To: David Lay From: Mike Nugent
Fax: 772-1070 Date: December 22, 2003
Phone 772-3846 Pages: 1
Re: 340 Commercial St.

I have reviewed the submissions for Permit #031067 and have the following questions/comments:

THE GULF OF MAINE
RESEARCH LABORATORY

E5 STAIR E SECTION
1/4" = 1'-0" AE402

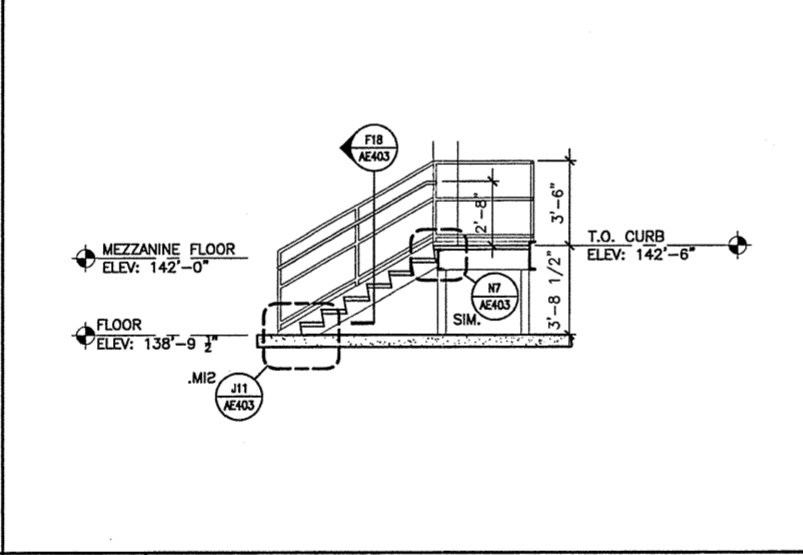
4. The handrail in fig. E5 on page AE402 is 32", (must be 34")

E13 ALT. TREAD STAIR PLAN
1/4" = 1'-0" AE103, AE104

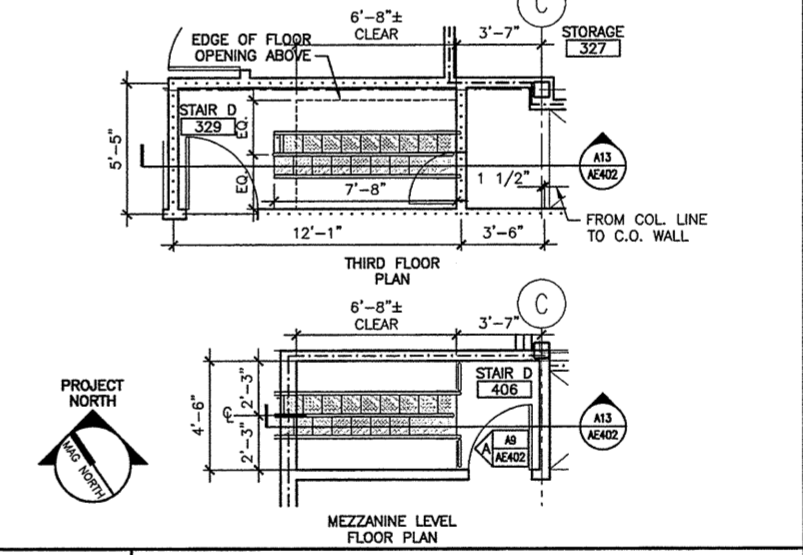
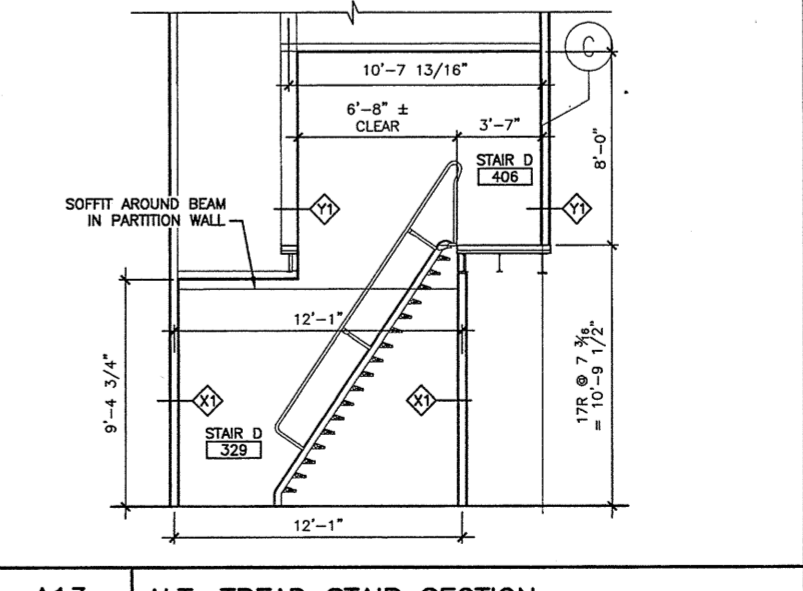
1. I need dimensional detail for the alternating tread stair that shows treads risers width
and guards, please look at Section 1014.6.6 and 1022.0.
